## **Peartree Hill Solar Farm**

# **Environmental Statement Addendum**

Application Document Ref: EN010157/APP/8.2

July 2025

Figure 14.3: Public Rights of Way and Long Distance Paths Within and Adjacent to the Proposed Development

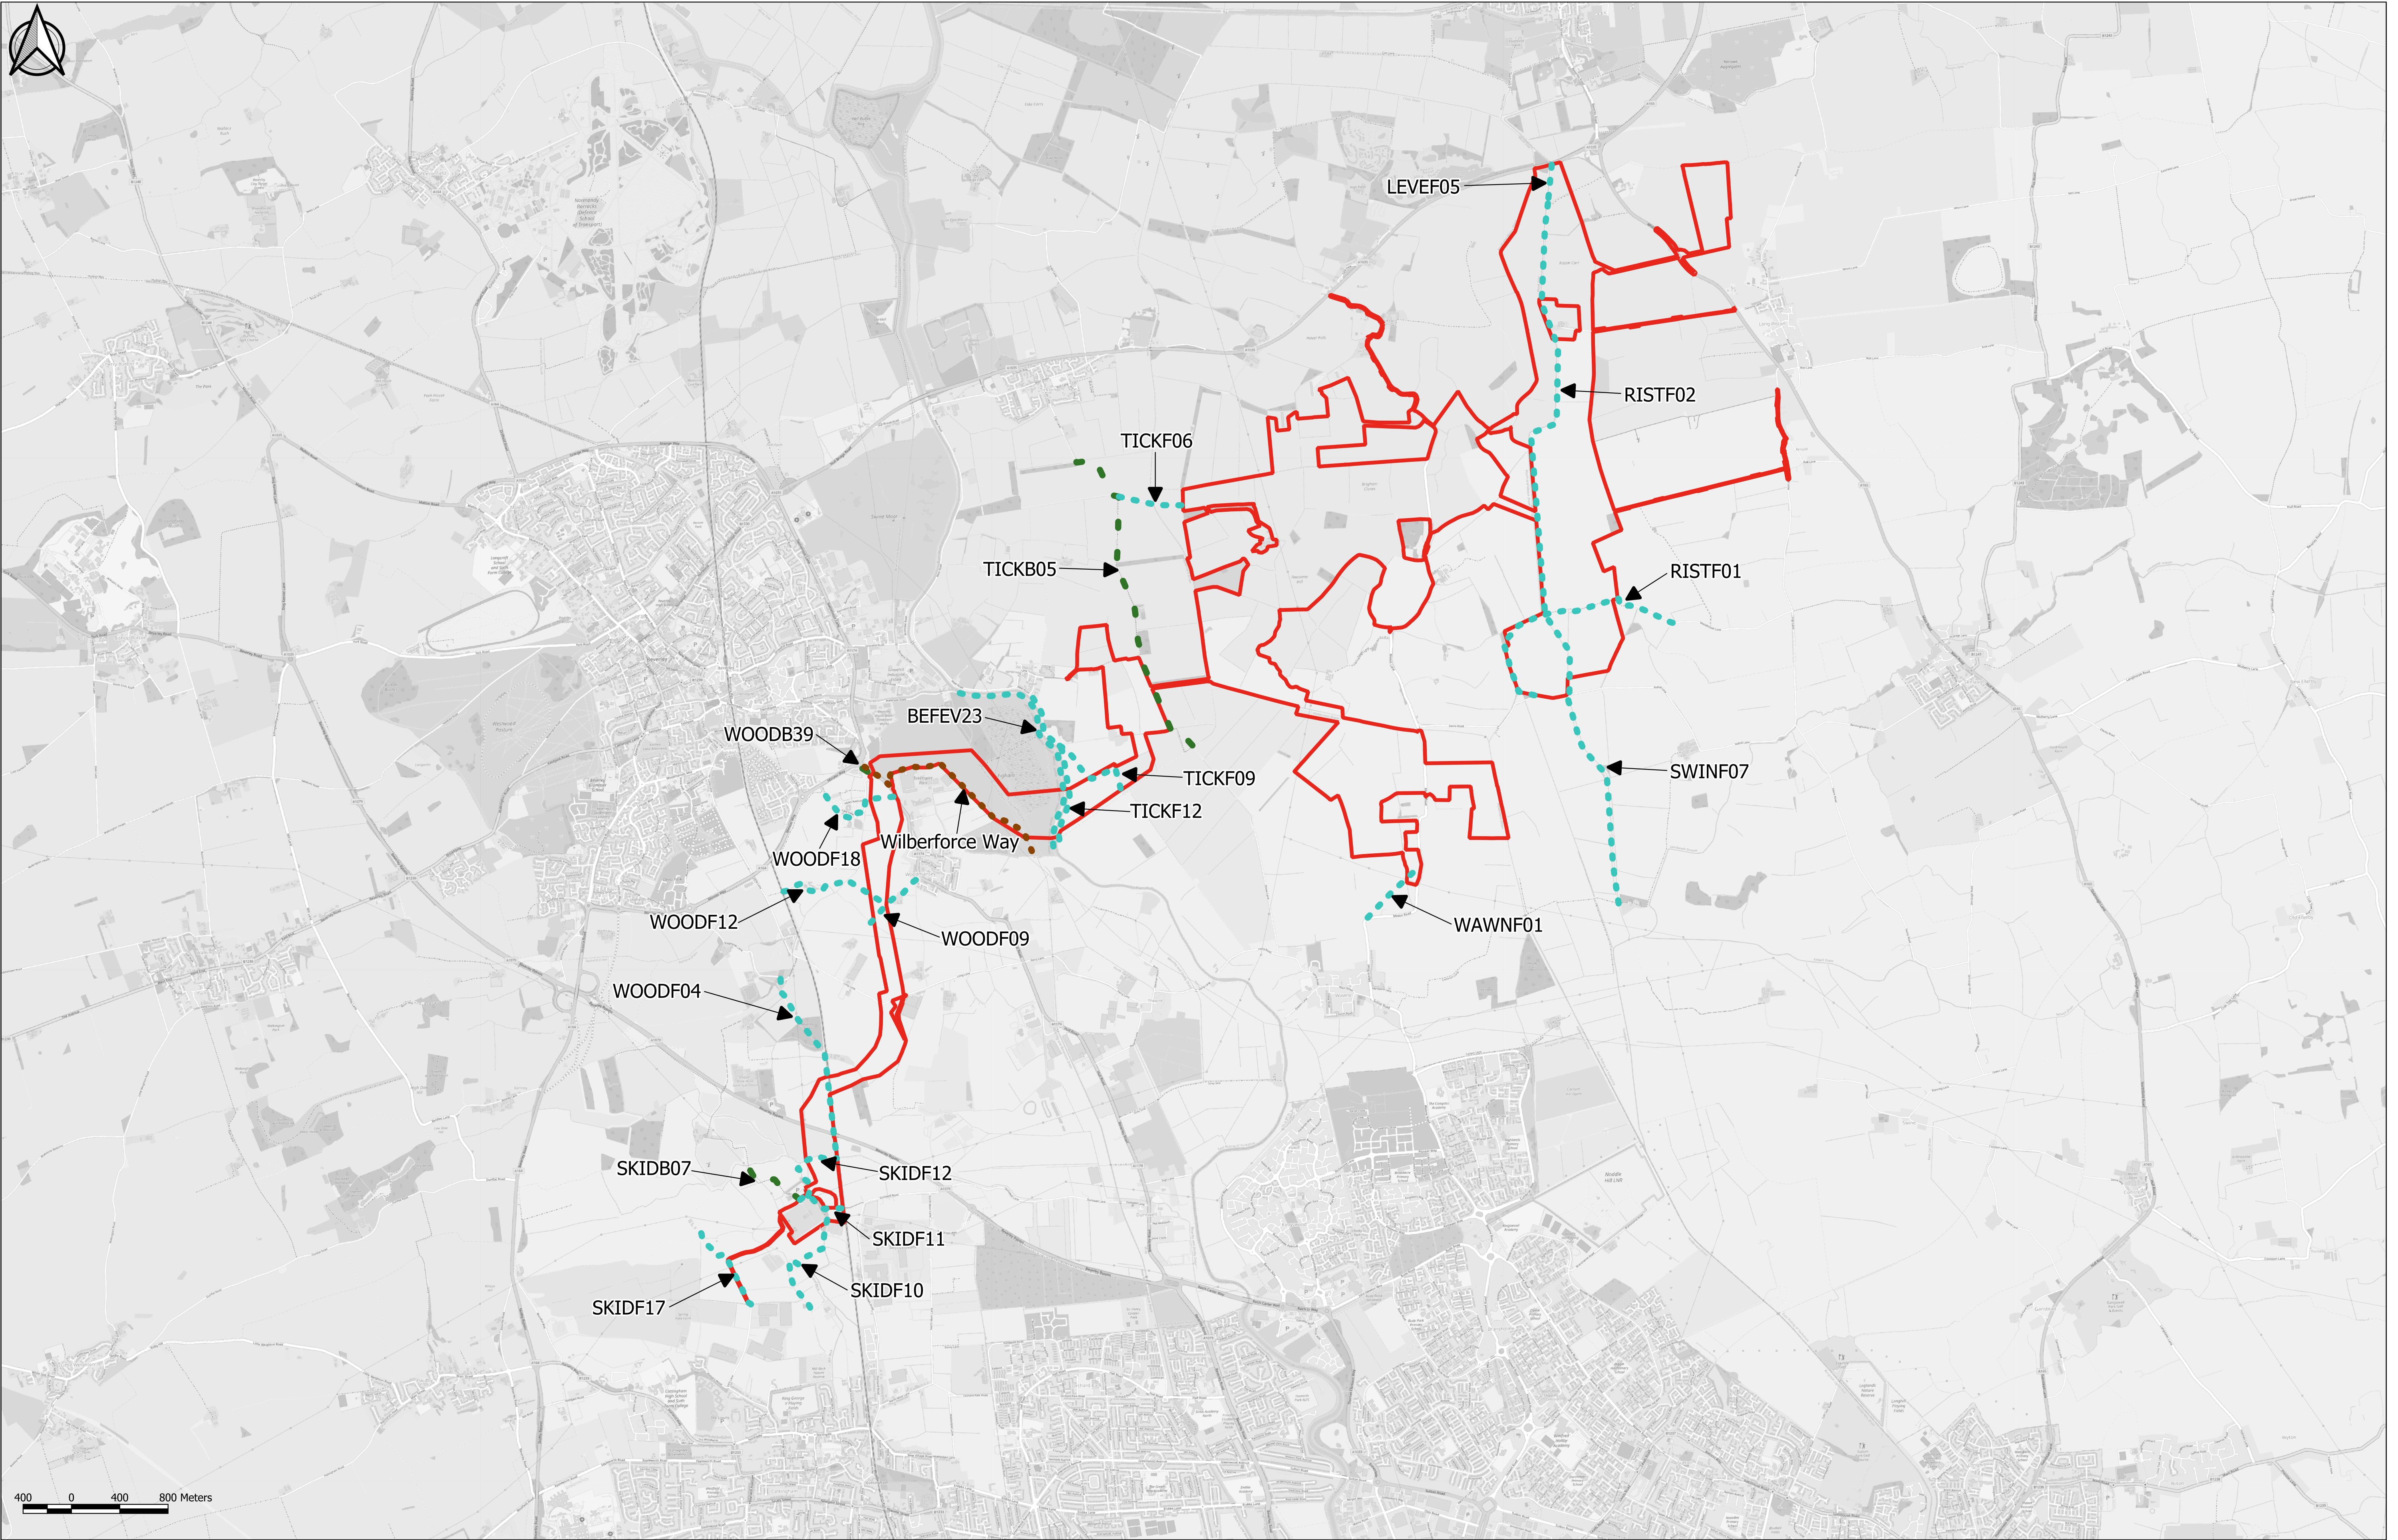
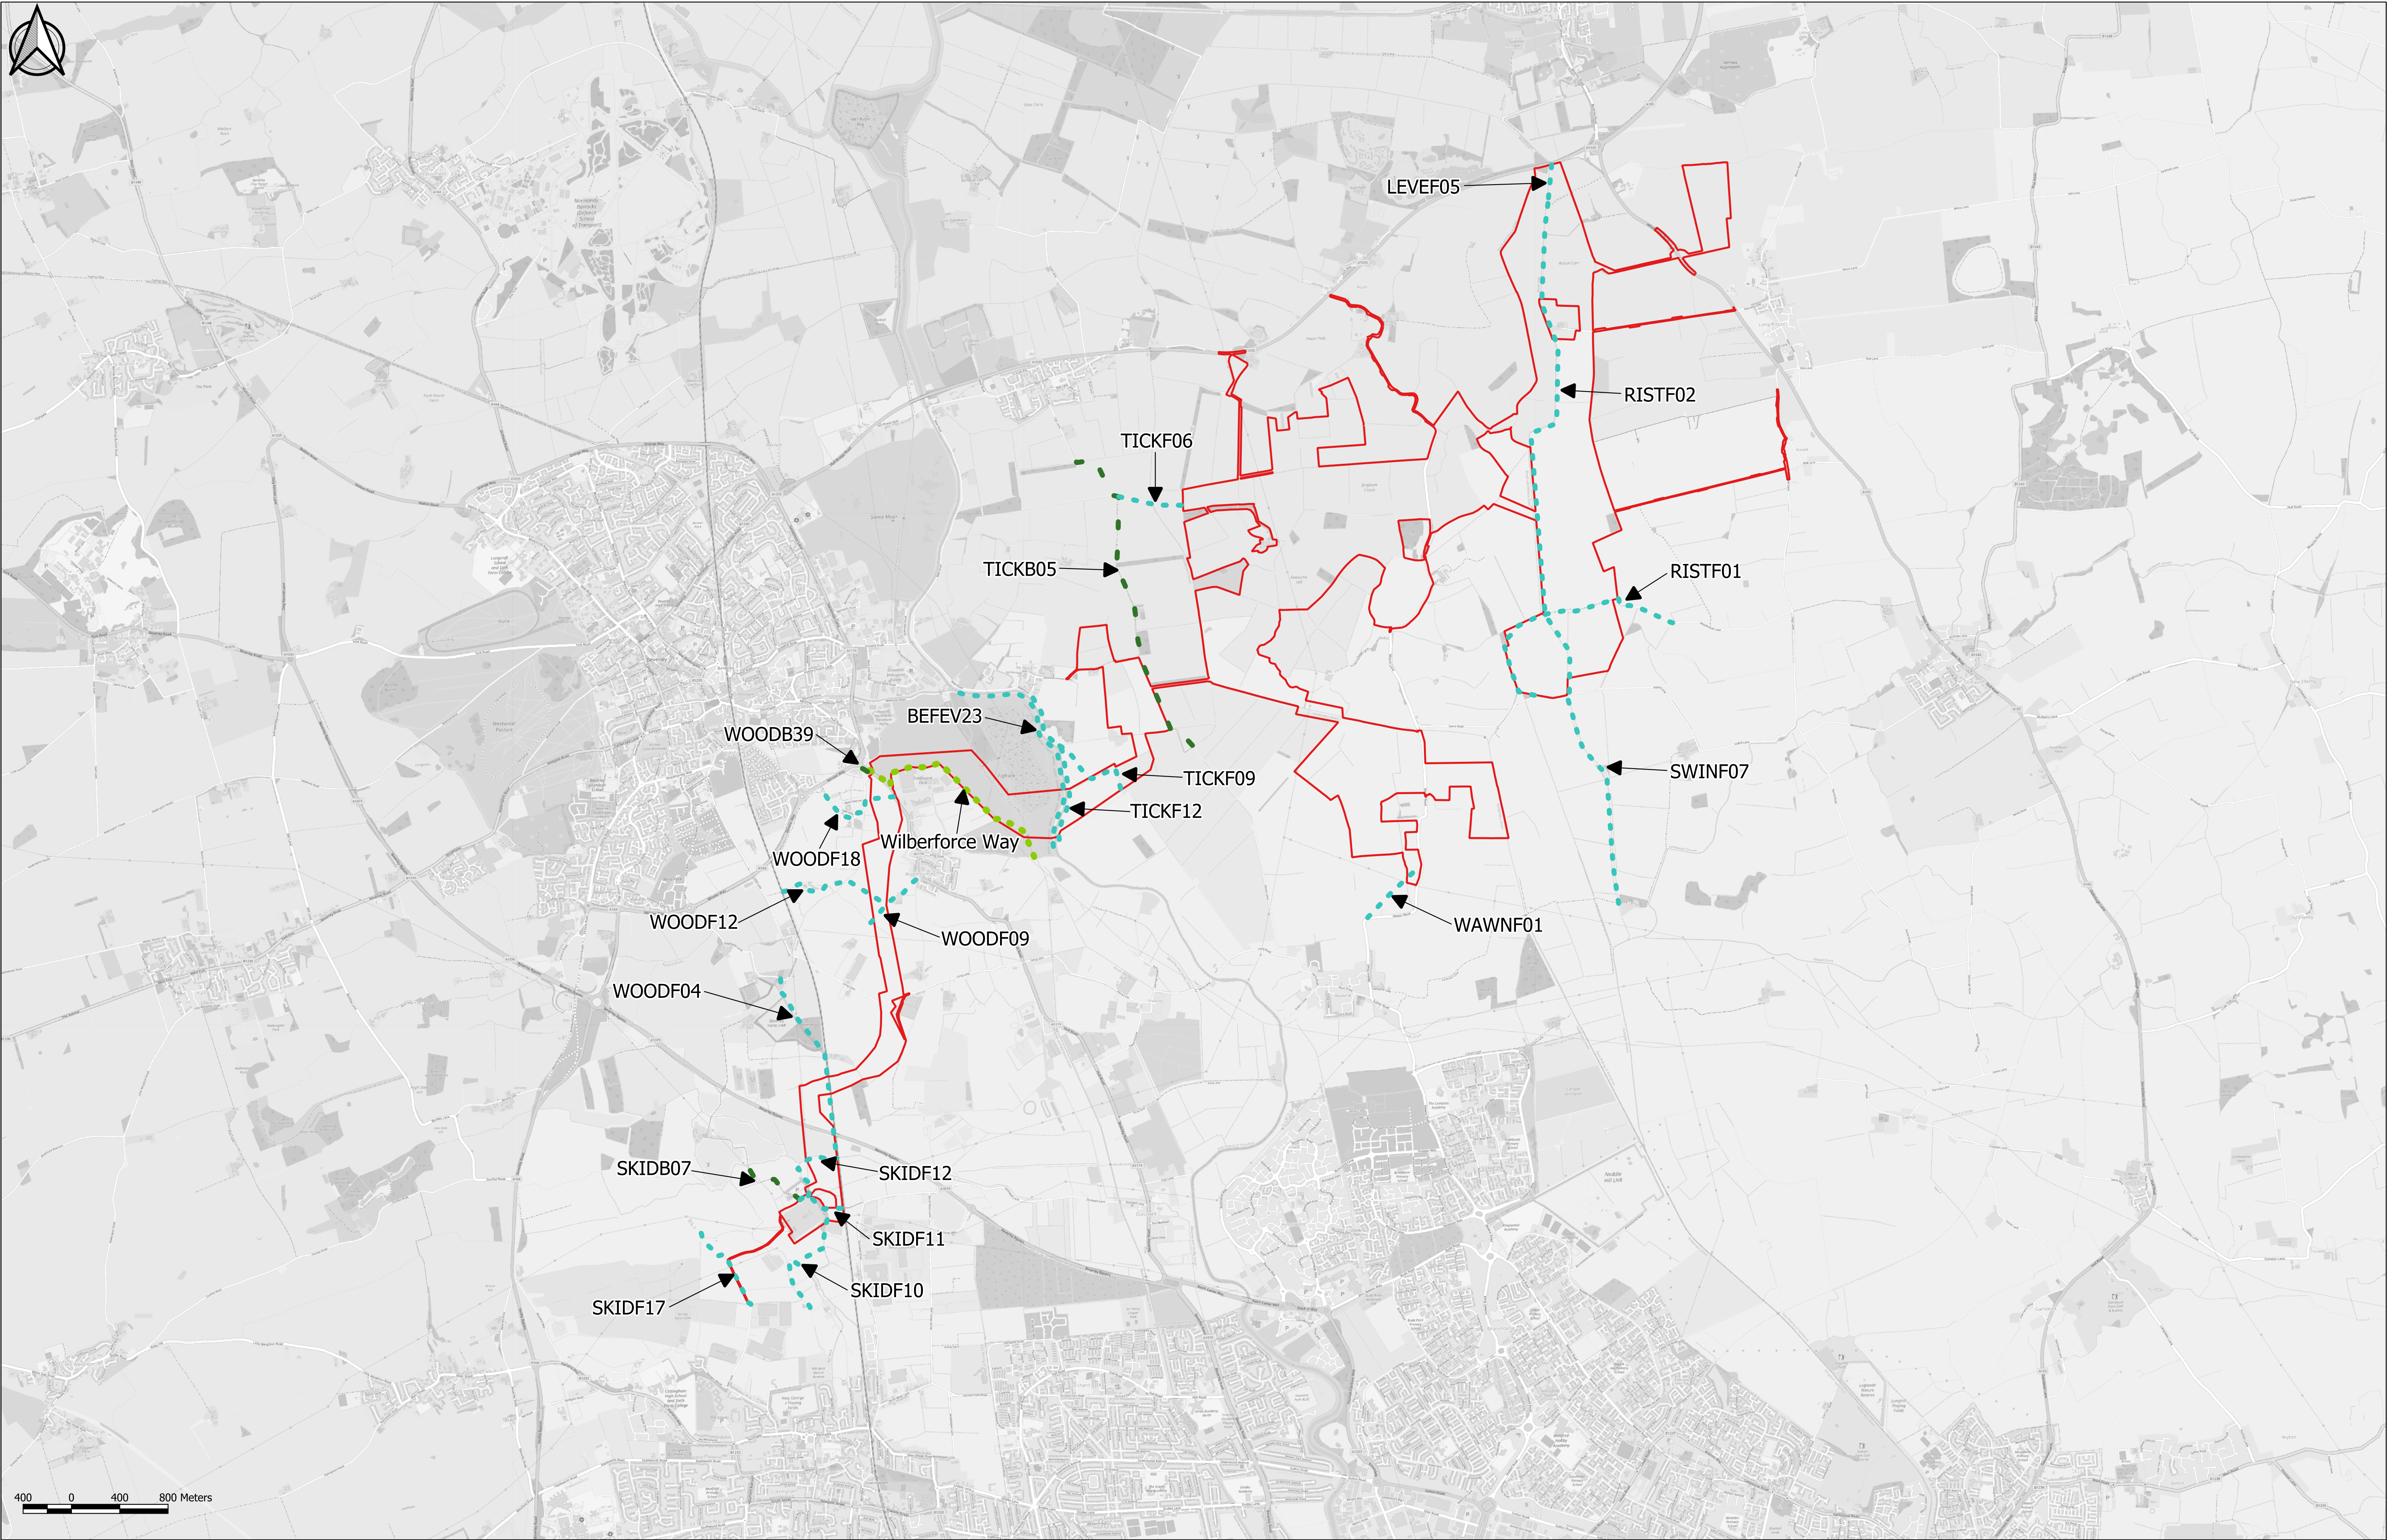
ES Volume 3, Figure 14.1: Study Area for Transport and Access [APP-089]	Figure 14.1 requires amendment to reflect the removal of plots 10-4, 10-5 and 10-6 as part of change/correction 2.	
ES Volume 3, Figure 14.2: Transport Routing and the Existing Highway Network [APP-090]	Figure 14.2 requires amendment to reflect the removal of plots 10-4, 10-5 and 10-6 as part of change/correction 2.	
ES Volume 3, Figure 14.3: Public Rights of Way and Long Distance	Figure 14.3 requires amendment to reflect the removal of plots 10-4, 10-

Paths Within and Adjacent to the Proposed Development [APP-091]	5 and 10-6 as part of change/correction 2.	
ES Volume 3, Figure 14.4: Link Sensitivity [APP-092]	Figure 14.4 requires amendment to reflect the removal of plots 10-4, 10-5 and 10-6 as part of change/correction 2.	
ES Volume 3, Figure 15.1: Other Existing and/or Approved Development [APP-093]	Figure 15.1 requires amendment to reflect the removal of plots 10-4, 10-5 and 10-6 as part of change/correction 2.
